From: Laura Gibbons
Sent: 04 May 2018 11:42
To: Planning.Responses
Subject: RE: Planning Consultation on R/85/18/DOC

APPLICATION NO: R/85/18/DOC

Registered: 27-APR-18
Site Address: Rustington Convalescent Home Sea Road RUSTINGTON
BN16 2LZ

Description of Works: Application for approval of details reserved by conditions 20 & 22 imposed on planning reference R/187/16/PL relating to surface water strategy

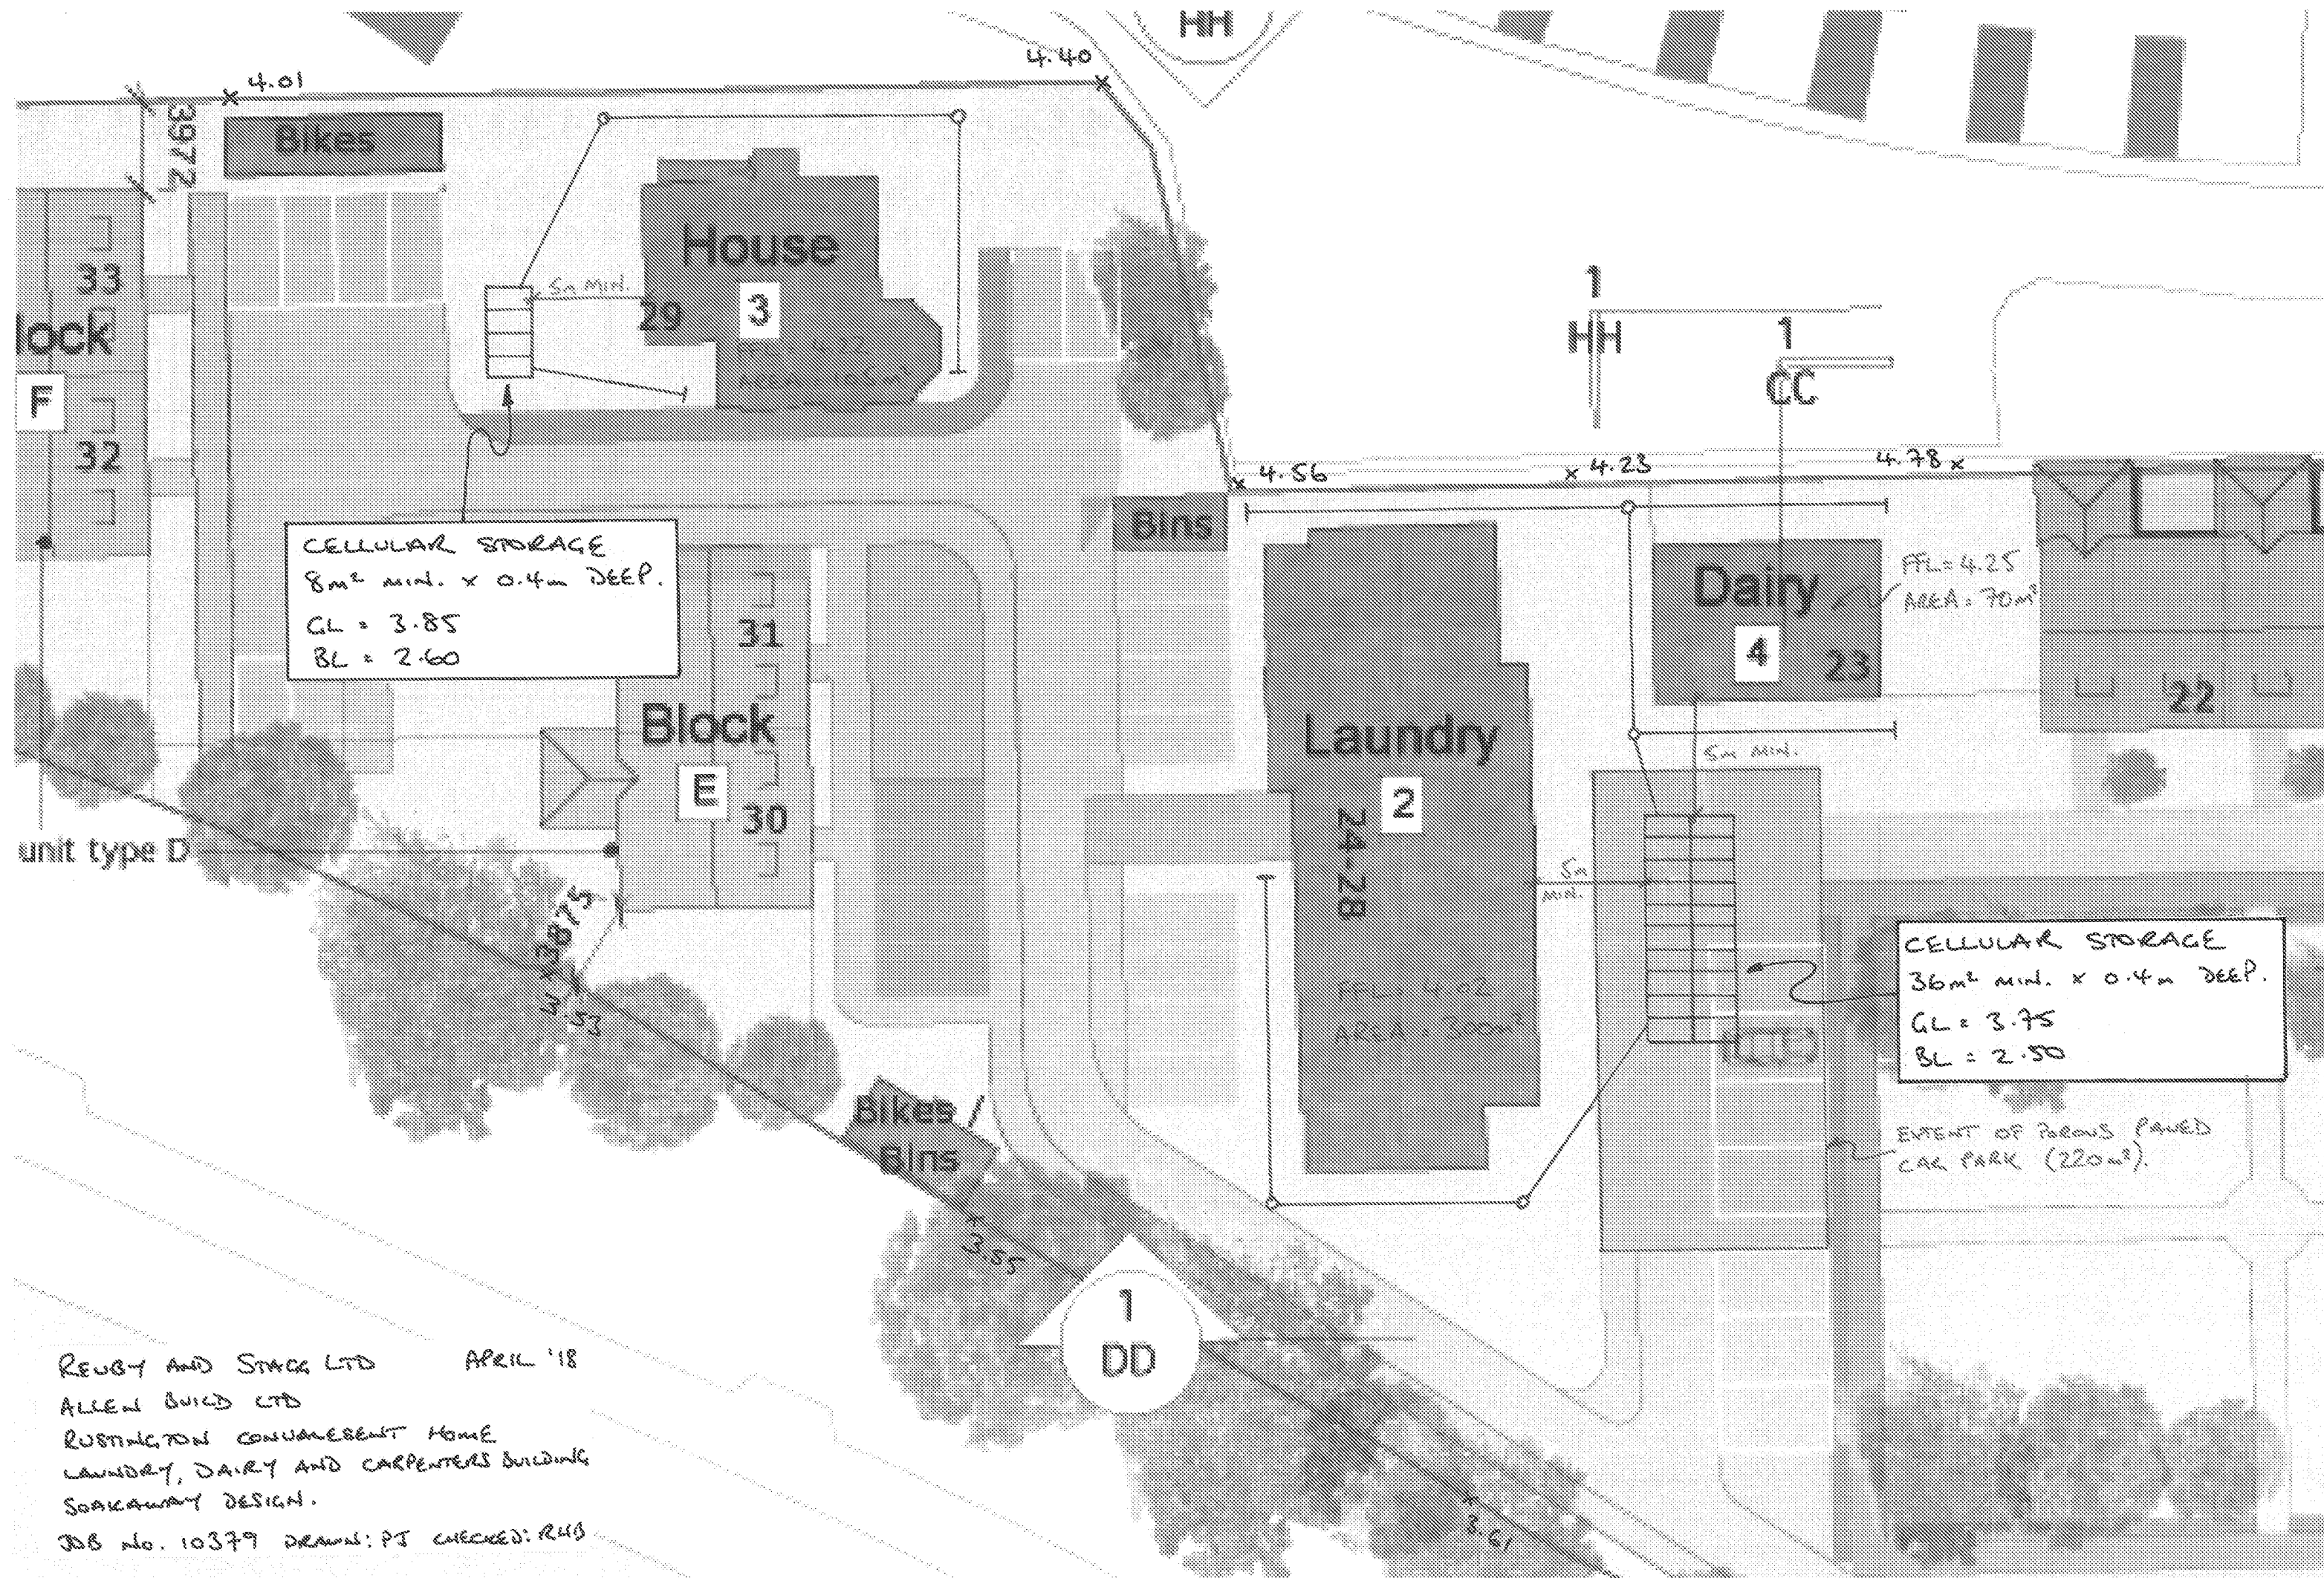
2. The infiltration coefficient used in calcs for the sides of infiltration structures is wrong by a factor of 10. This will need revising anyway following new infiltration test results.

SOAK AWAY TEST NO: 2

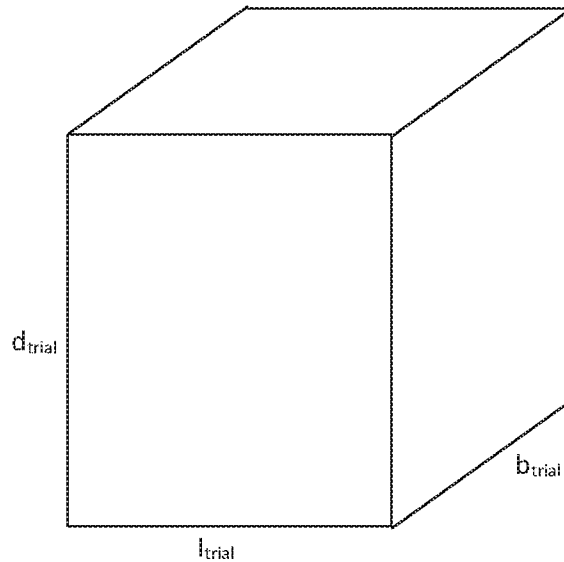
1. Please re-do infiltration tests as a matter of urgency ensuring the base of test pits as at the proposed invert level of infiltration structures. The test results provided are for a pit dug 3m deep (below the maximum recorded ground water level of 2.26m below ground level) and into the chalk sub strata. Borehole logs show that the proposed base of infiltration structures will be in clay so we expect a far lower infiltration rate will be found, closer to the 5.6×10^{-6} stated in the 2015 flood risk assessment and drainage strategy supplied. Why has a different test been used? Was this original 2015 test giving 5.6×10^{-6} m/s not conducted in the winter?
